STATE OF NORTH CAROLINA
DEPARTMENT OF TRANSPORTATION

May 8, 2013

Subject: **Response to On Hold Letter** for request for Section 401 Water Quality Certification Modification, Wilmington Bypass from north of US 74/76 in Brunswick County to US 421 in New Hanover County. DWQ Project No. 10-0867v.4. TIP R-2633B.

Reference: NCDOT Modification Request, dated April 3, 2013
NCDWQ On Hold Letter, dated April 19, 2013, received April 26, 2013

PERMIT DRAWING
SHEET 20i OF 73
1/20/15

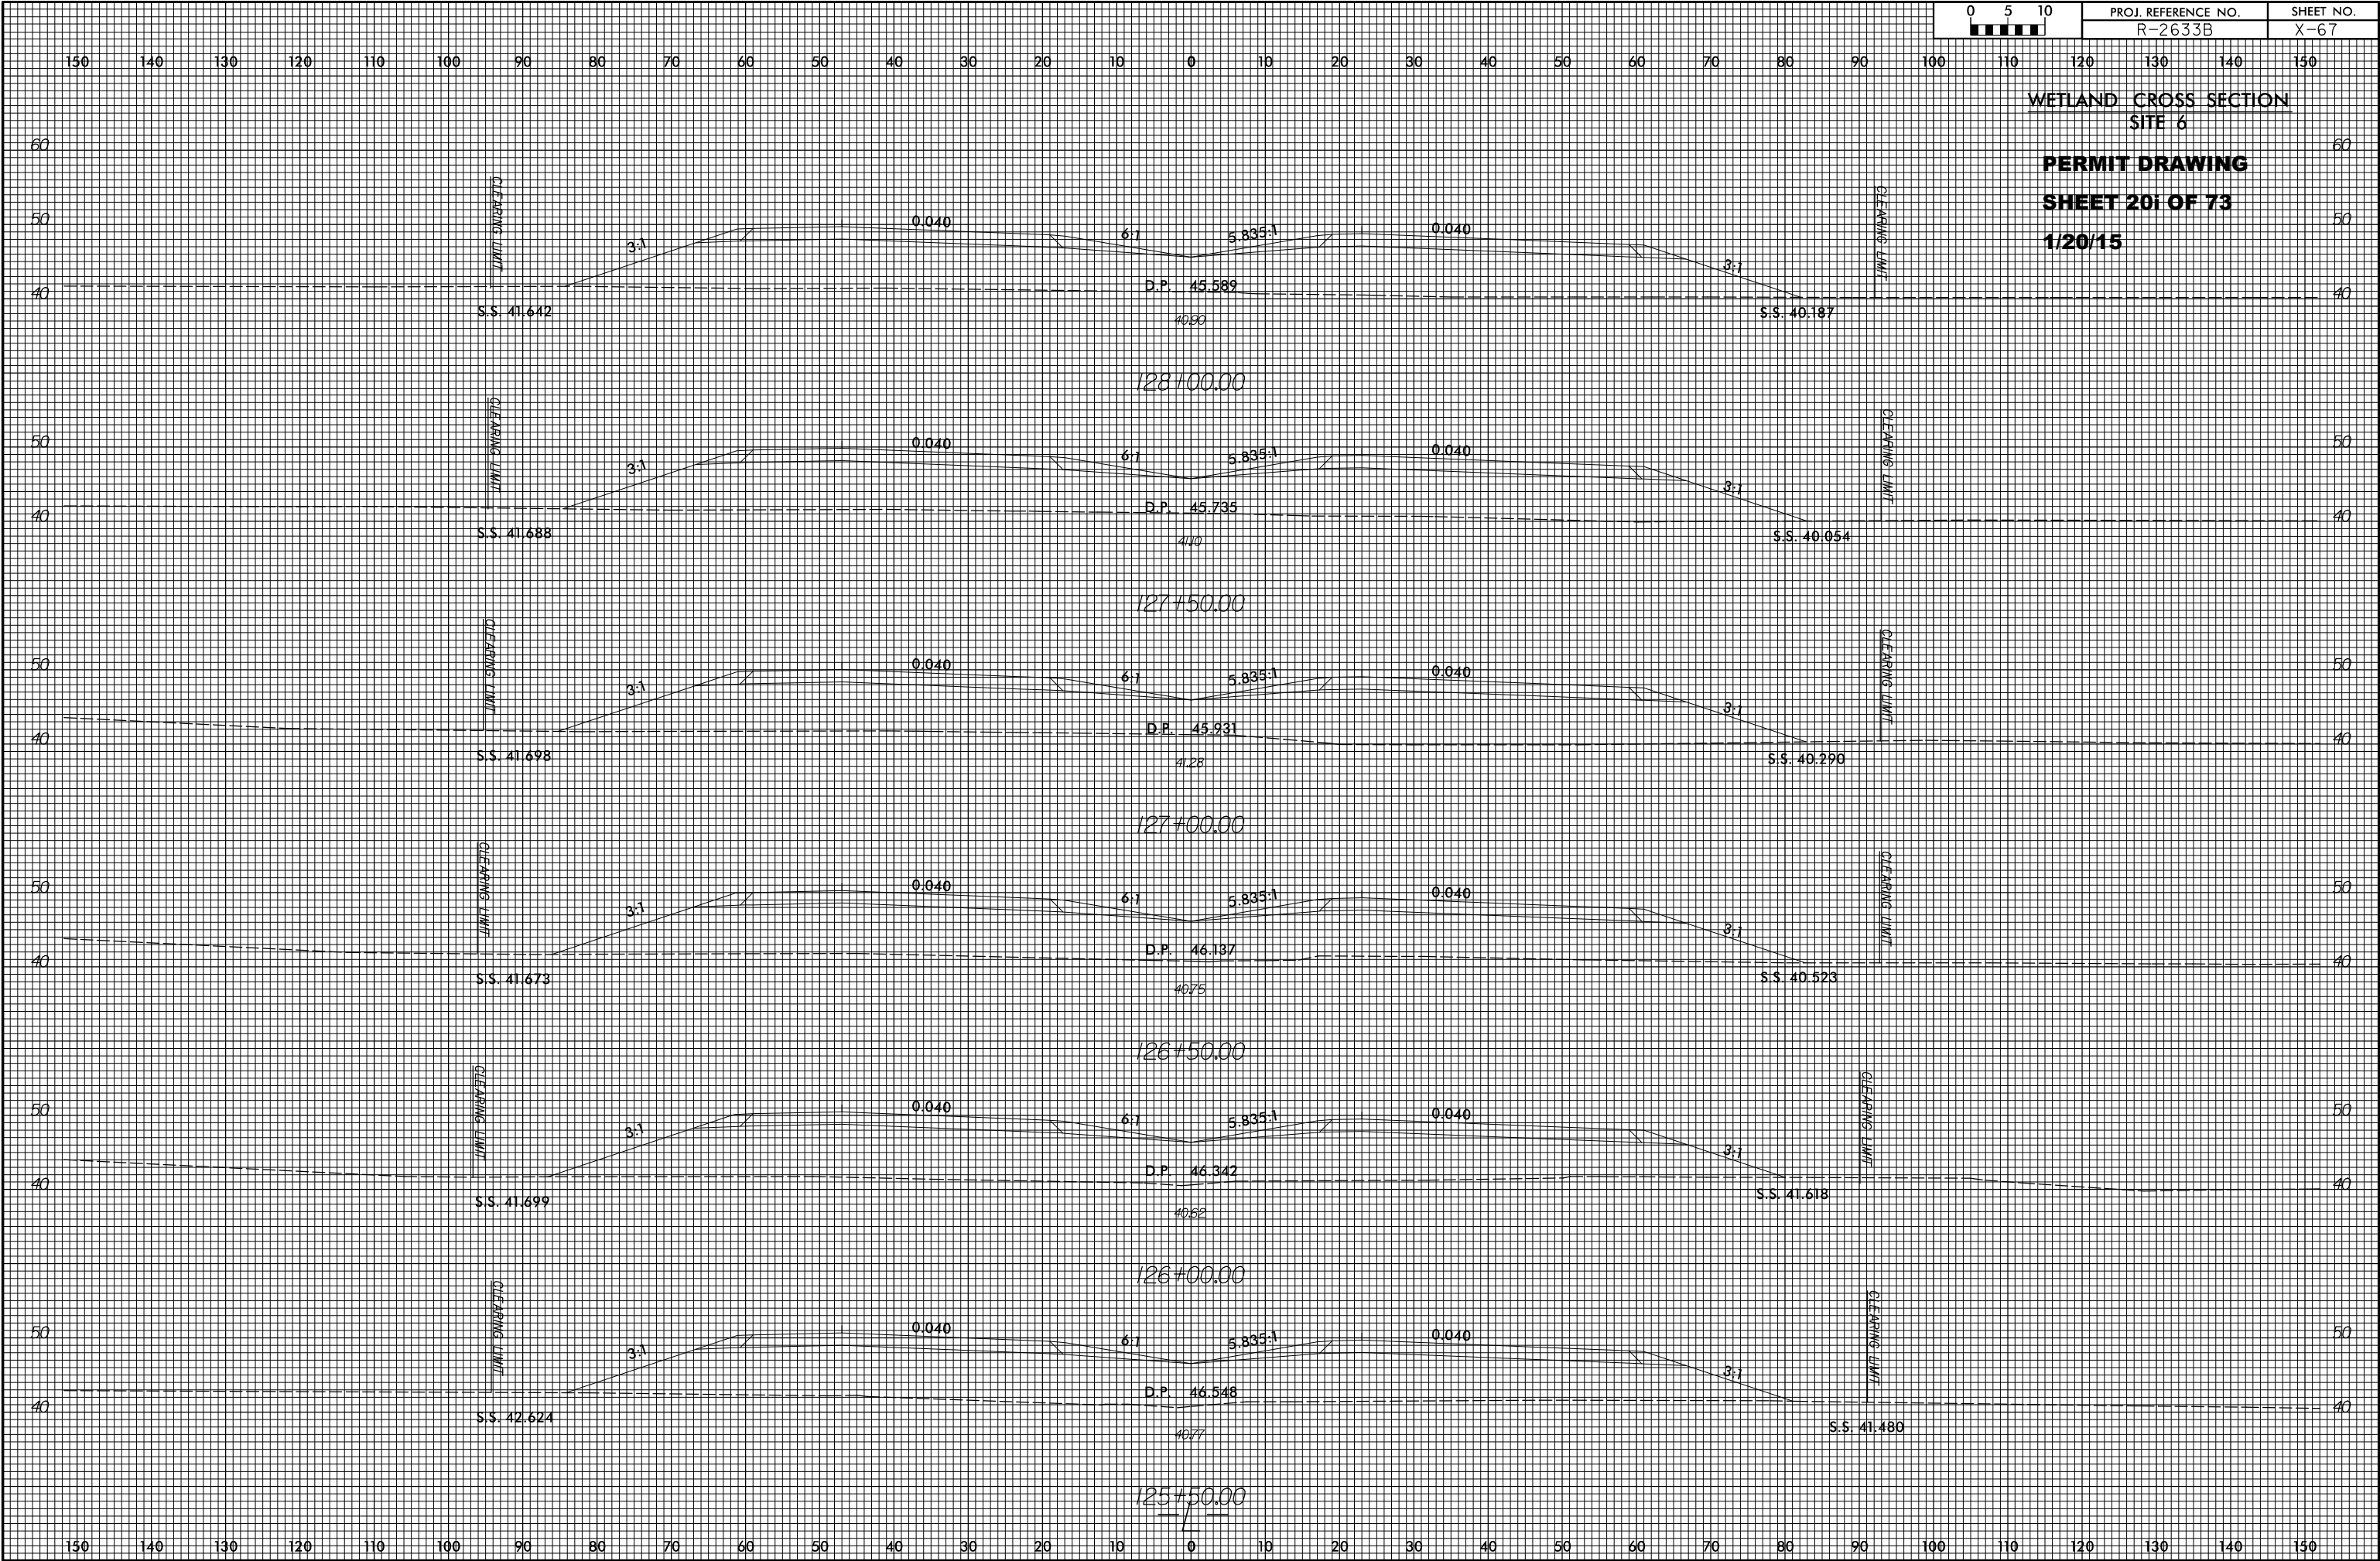
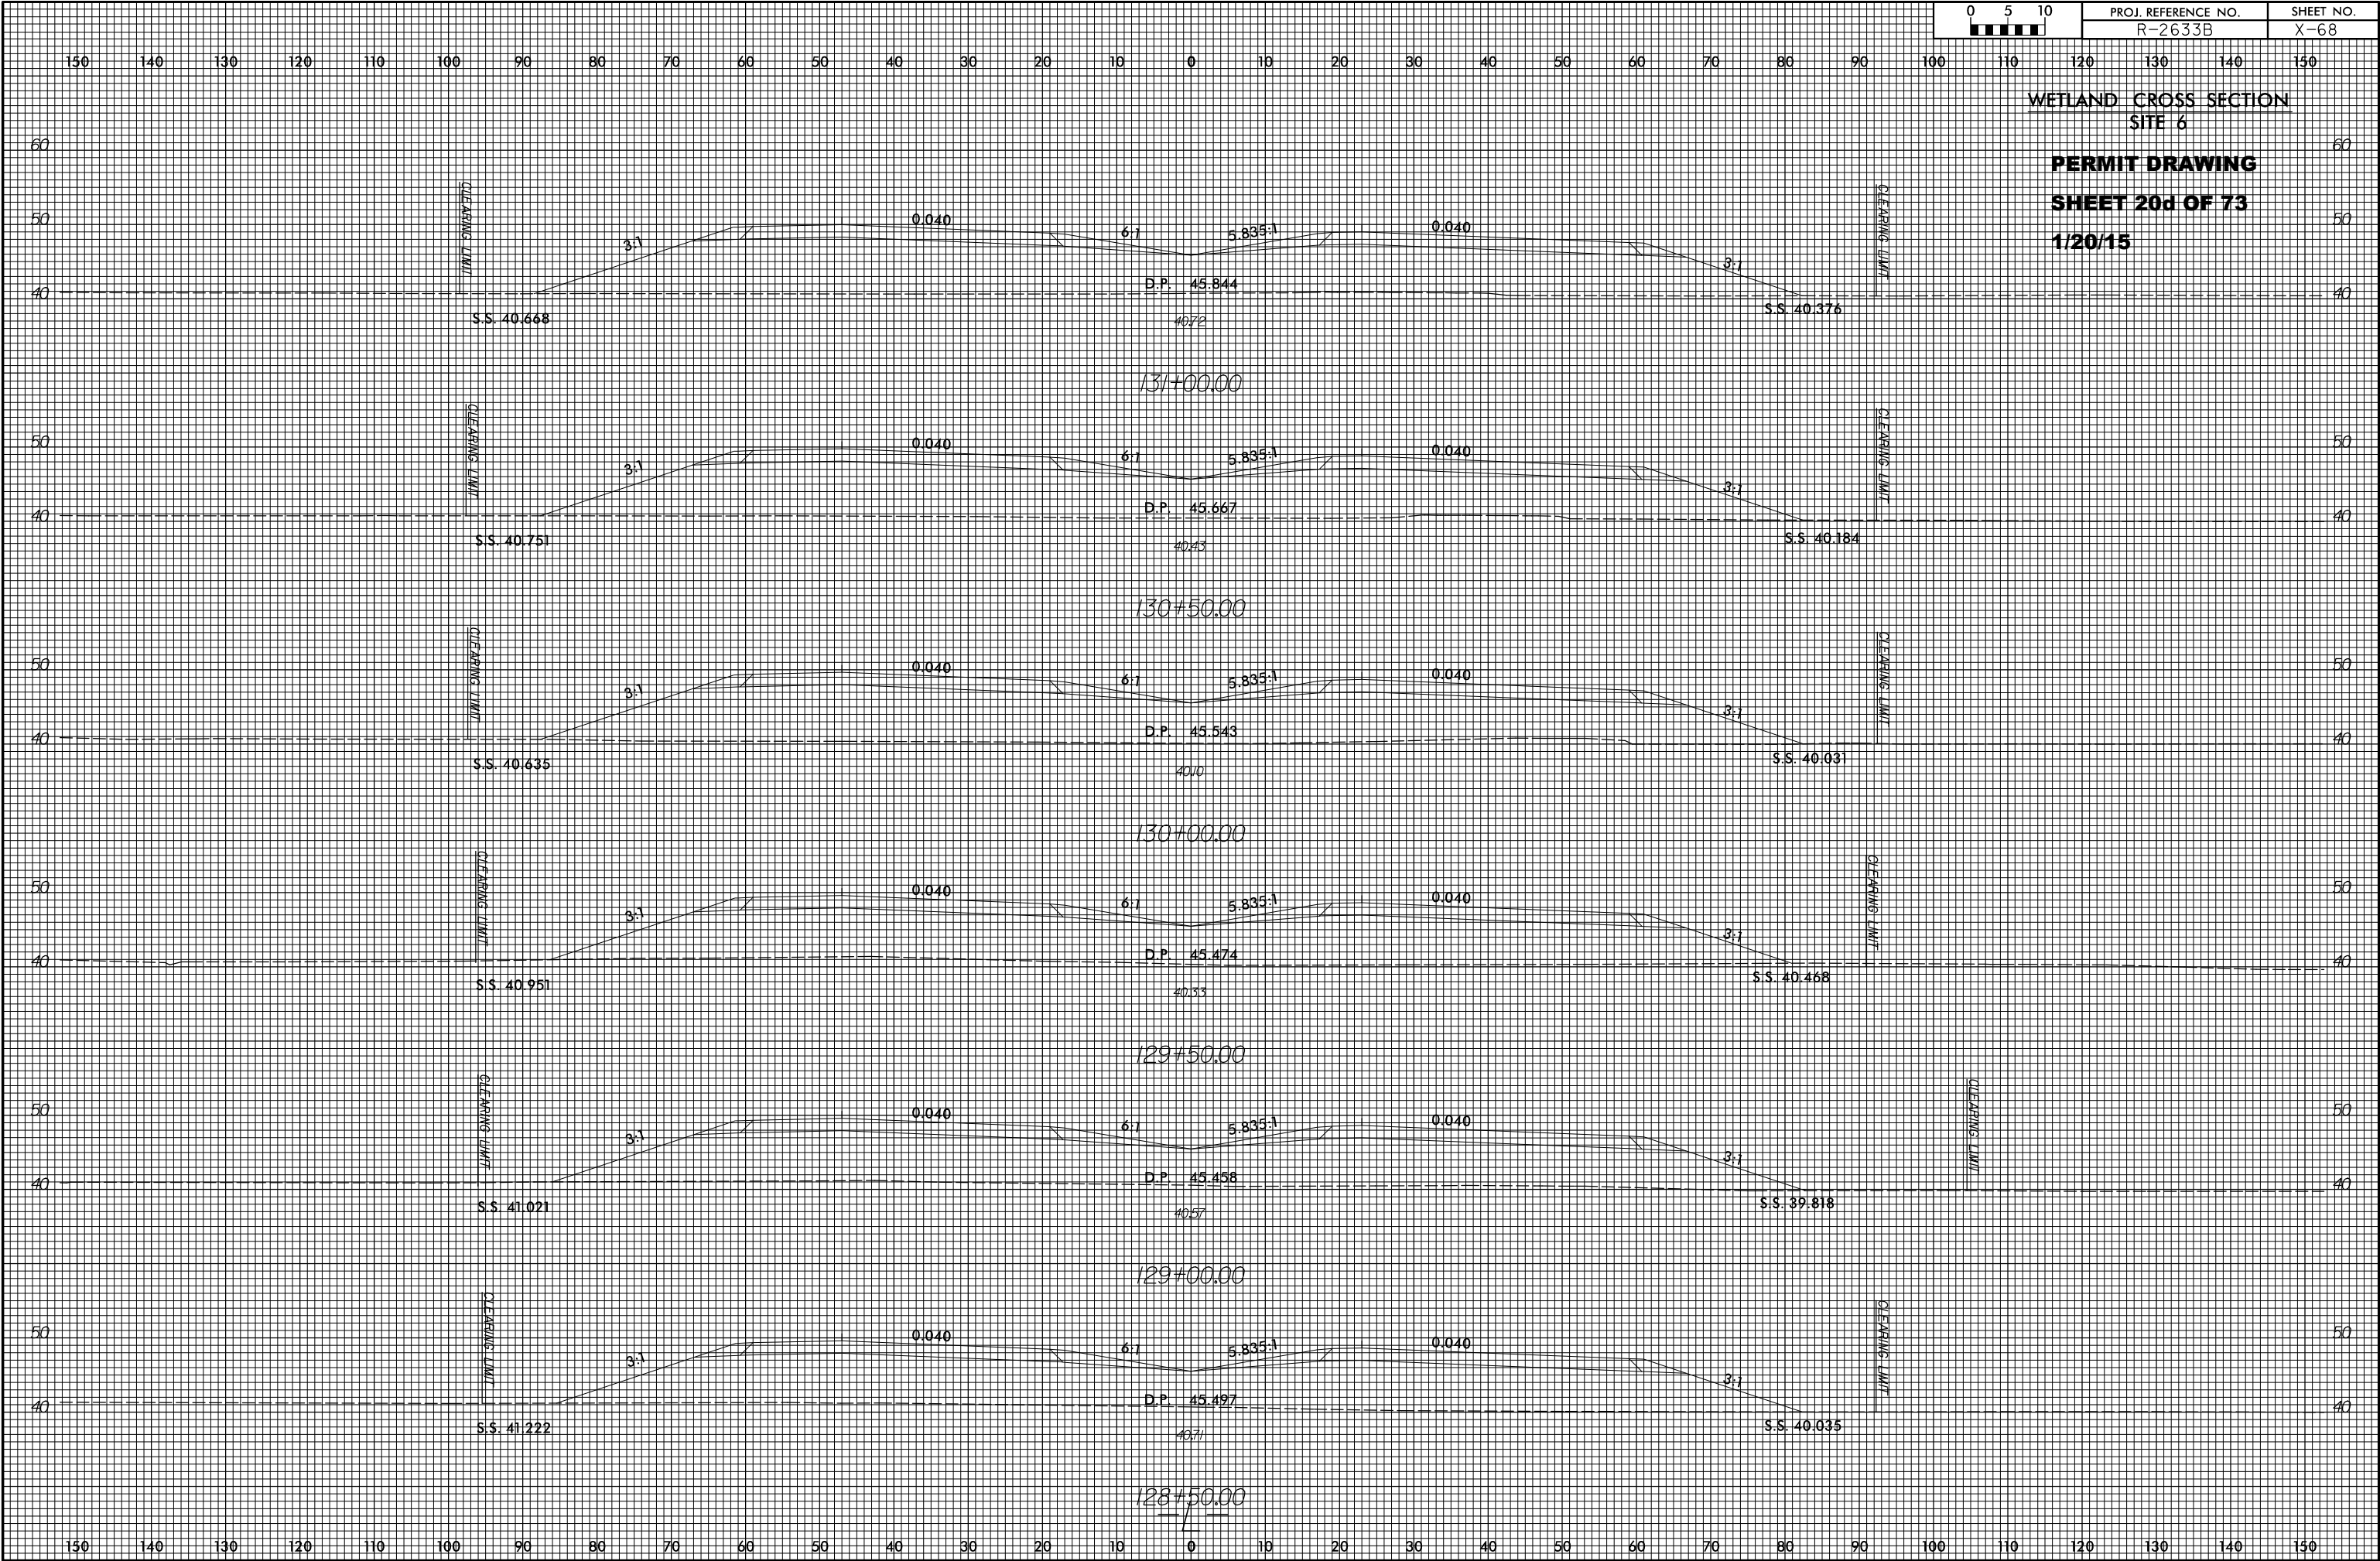
2. Site 6 – no cross sections were provided for the wetland impacts between Sta. 109+28 to 118+00 and 123+00 to 135+00. Please provide these cross sections.

3. Your application states in the "Avoidance and Minimization" section that 3:1 slopes will be used in wetland areas to minimize wetland impacts. Upon review of the application there are several cross sections that show greater than 3:1 slopes. Please correct.

Representative cross sections were provided in the application. Nevertheless, additional cross sections are enclosed, providing a larger sampling of cross sections in jurisdictional areas.

Sites 3, 5 & 6 permit drawings, cross sections, and impact summary sheet have been revised and are enclosed. As a result, proposed permanent fill has decreased at these sites by 1.42 acres. Additionally, we will submit a revised request to EEP for an updated acceptance letter.
